Access Design Assessment Report
Development Application

Budawang School
Milton NSW 2538

Project: Budawang School
 Milton NSW 2538
 Document Type: Access Design Assessment Report
 Our Reference: P220_441-3 (ACCESS) FMR

1 SITE PLAN  
1 : 250

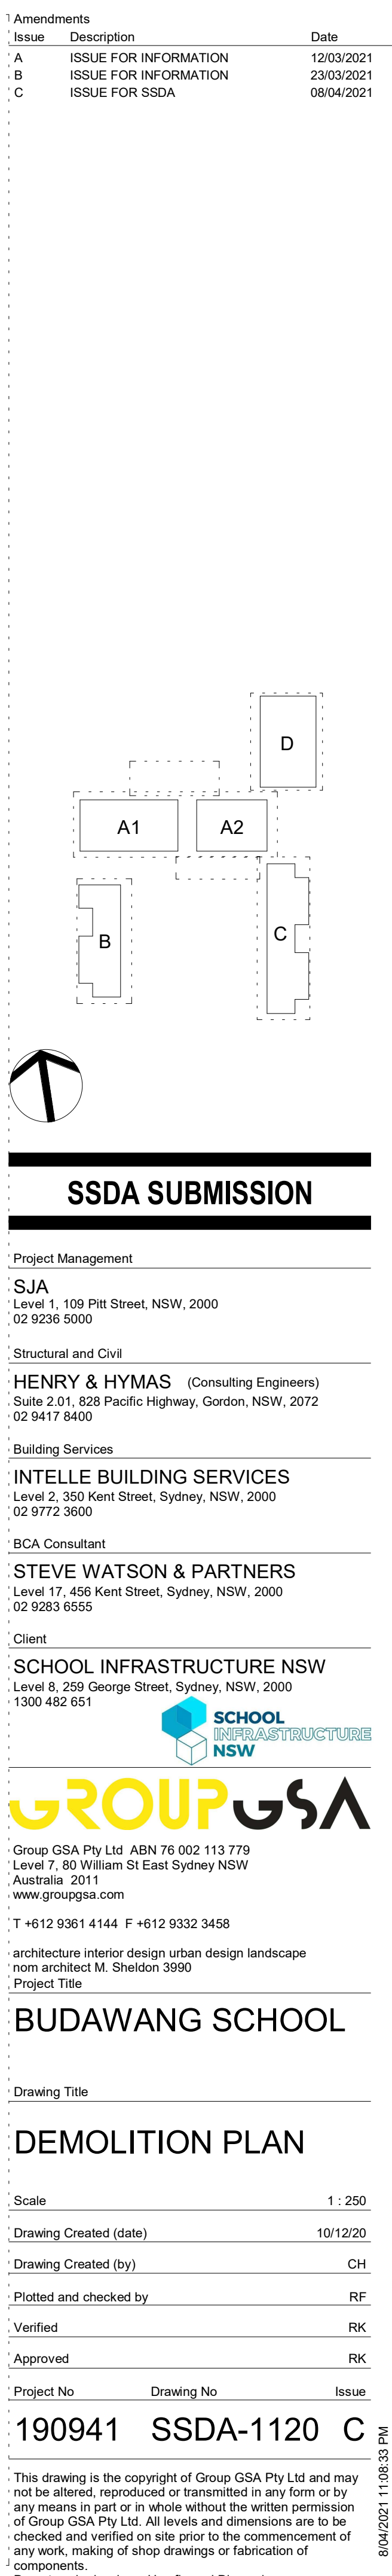
DESCRIPTION	COMMENT	RESOLUTION
Gates	<p>Clarification is required relating to gate at the site entry from Croobyar Road, being –</p> <ul style="list-style-type: none"> Discrepancy between the site plan (single leaf gate) and the Hydrotherapy plan (double leaf gate); For a single gate leaf per site plan, there is nil latch-side circulation provided 100mm rise in elevation from the path outside the site boundary to the proposed RL inside the boundary. 	<p>Clarification is required from the design team –</p> <ul style="list-style-type: none"> The gate at the main entry shall be in accordance with Clause 13 of AS1428.1-2009, including the required circulation spaces; Clarification required from the design team to ensure that a step-free path of travel through the main entry is achieved.
Proposed levels	<p>Concern is raised relating to the proposed levels along the external pedestrian paths.</p> <p>Refer to the drawing mark-ups in Appendix 4 below.</p> <p>In particular –</p> <ul style="list-style-type: none"> 1:20 gradient proposed at the entries to Block C; 1:20 gradient proposed adjacent to Block A2 and leading to Block D entry; Gradient at intersections of different paths; Discrepancies between the site plan and the GA plans. 	<p>An accessway in accordance with AS1428.1-2009 from the site boundary, from the accessible parking spaces and between buildings shall be achieved.</p> <p>Refer to the drawing mark-ups in Appendix 4 below for the relevant resolutions for each location.</p>

**1 BLOCK C PLAN**  
1:100

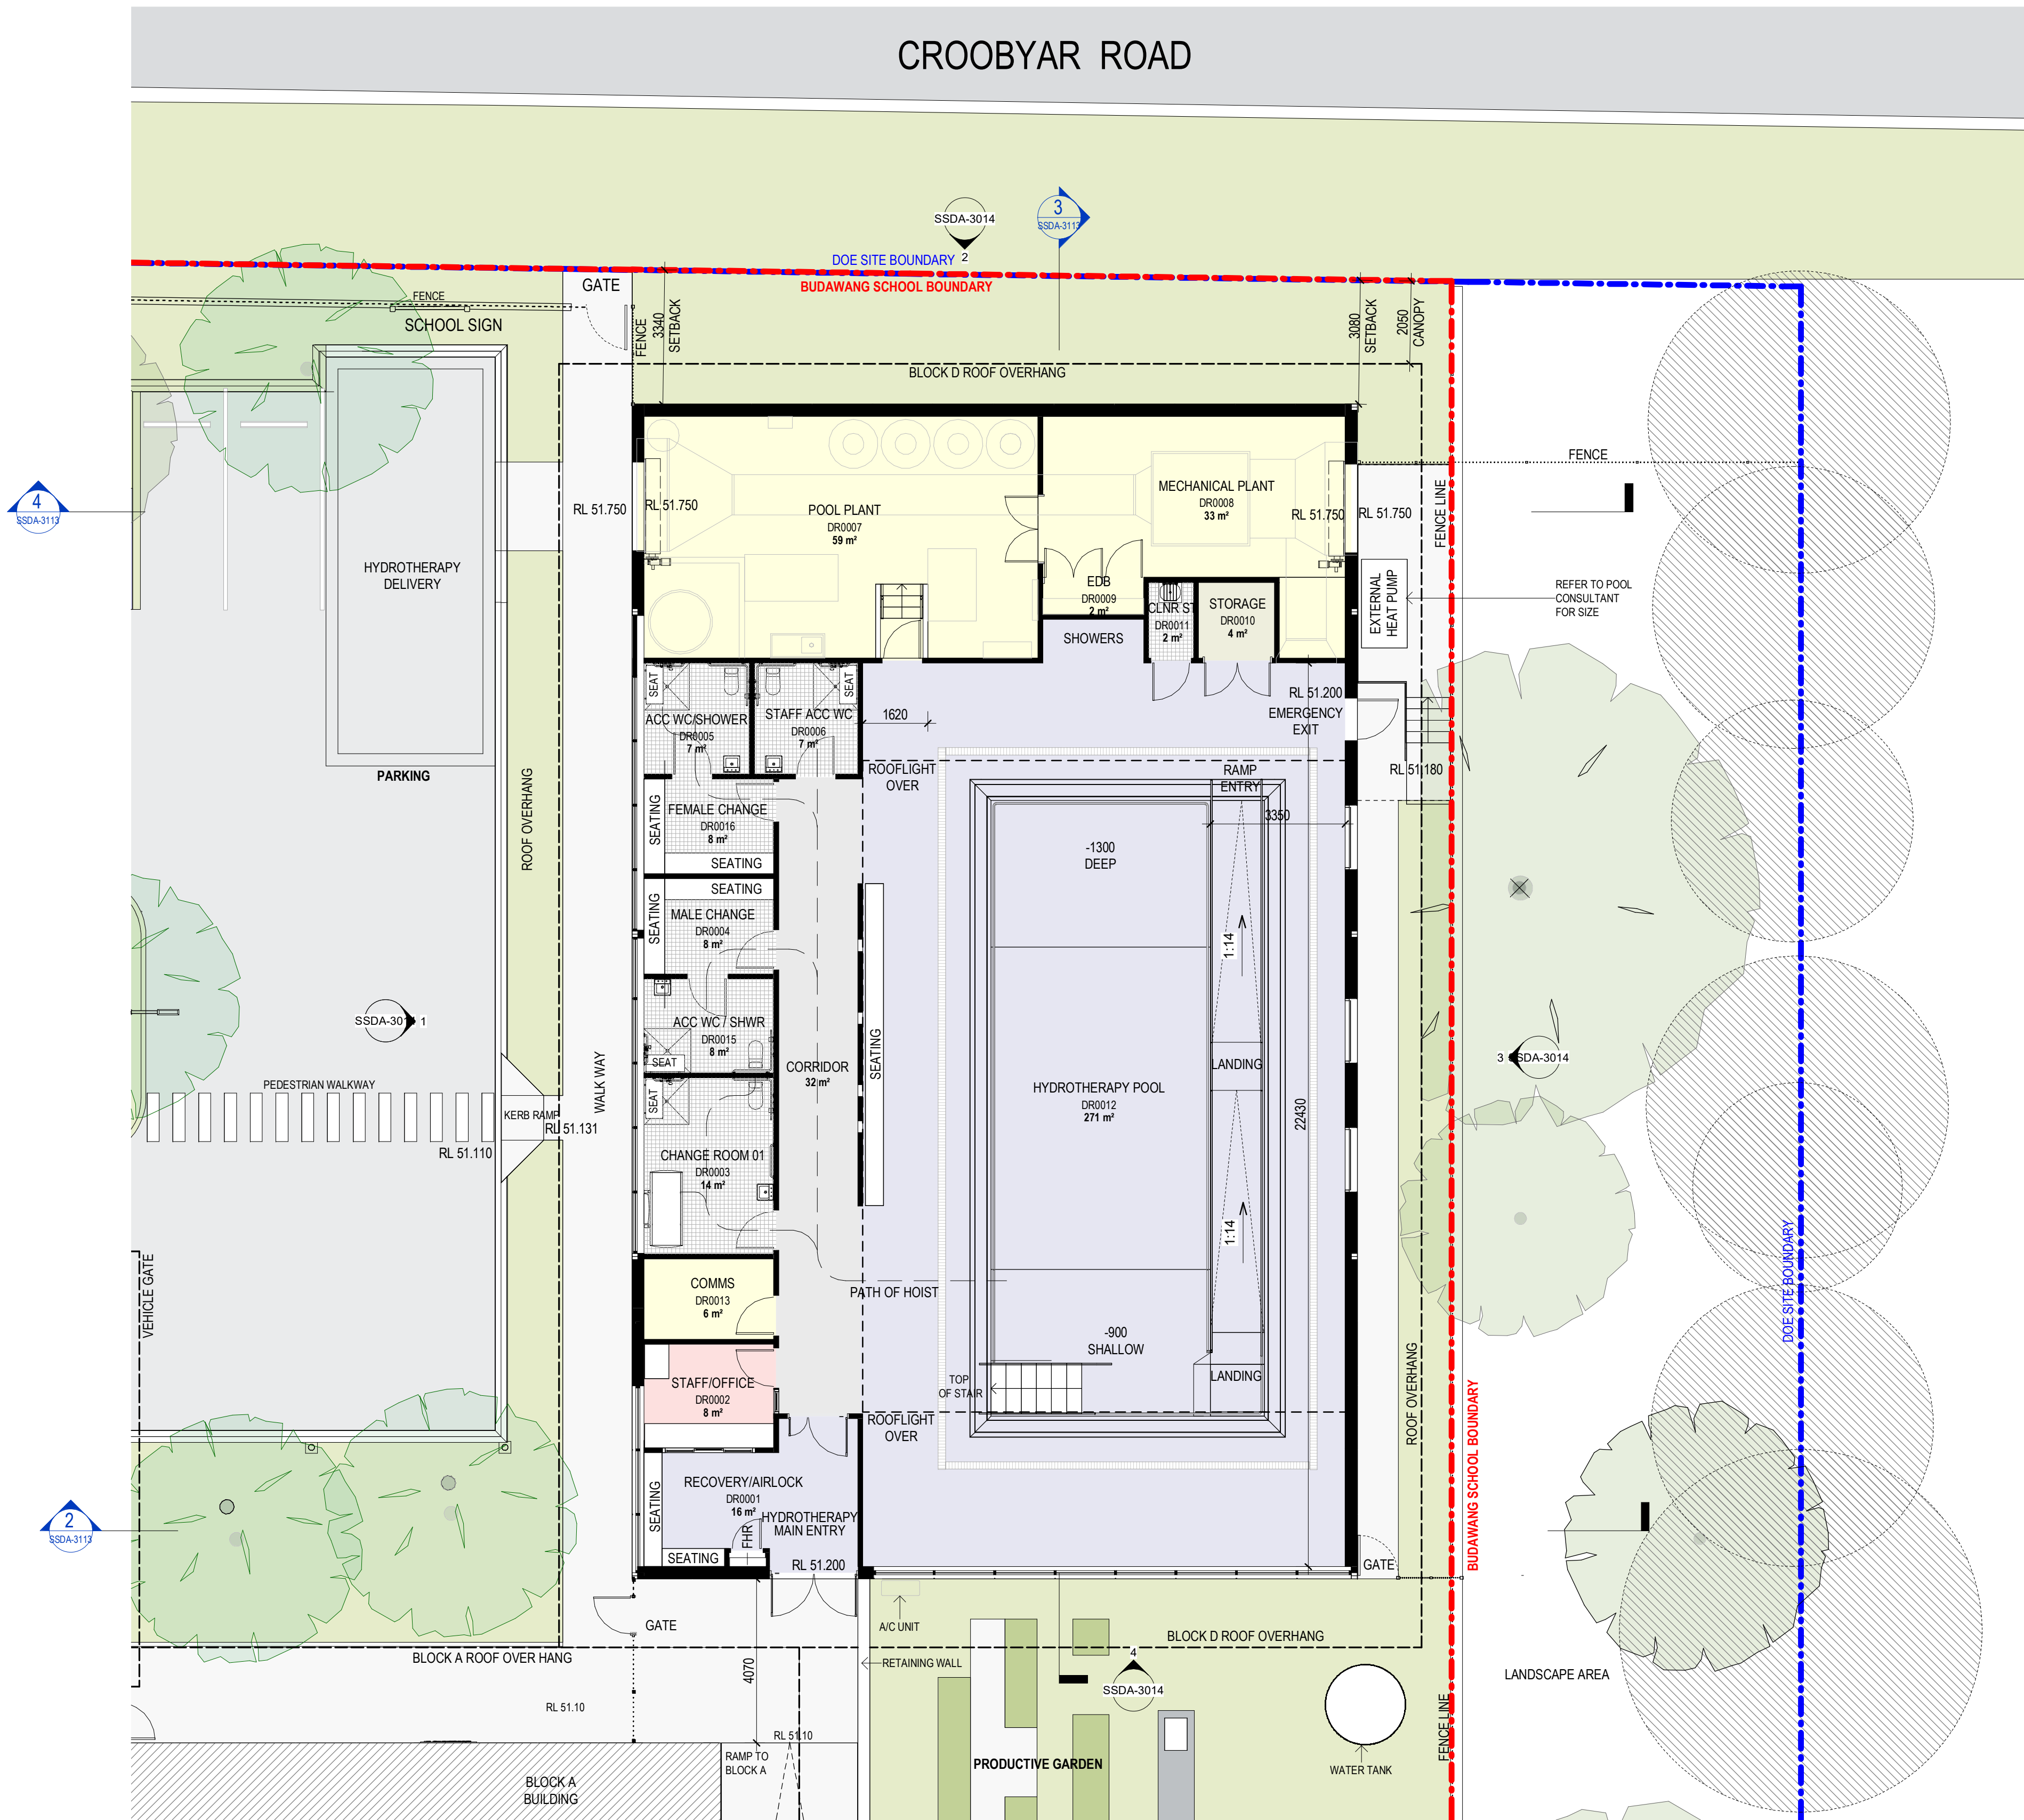
DESCRIPTION	COMMENT	RESOLUTION
Transfer side	<p>A total seven (7) accessible sanitary compartments for students are proposed as follows –</p> <ul style="list-style-type: none"> Block A1 (A1R0004) – RH; Block A2 (A2R0002) – RH; Block A2 (A2R0018) – LH; Block B (BR0002) – RH; Block C (CR0011) – LH; Block D – Female (DR0005) – LH; Block D – Male (DR0015) – RH. <p>Moreover, two (2) accessible sanitary compartments for staff are provided, being –</p> <ul style="list-style-type: none"> Block A1 (A1R0012) – LH; Block D (DR0006) – RH. 	Refer to comments below for further guidance.
Unisex facilities	Concern is raised whereby 2 x accessible WCs in the Hydrotherapy building are located within an area reserved of one sex only, being within the Male and Female Change rooms.	Clause F2.4(f) requires that an accessible unisex sanitary facility must be located so it can be entered without crossing an area reserved for one sex only.
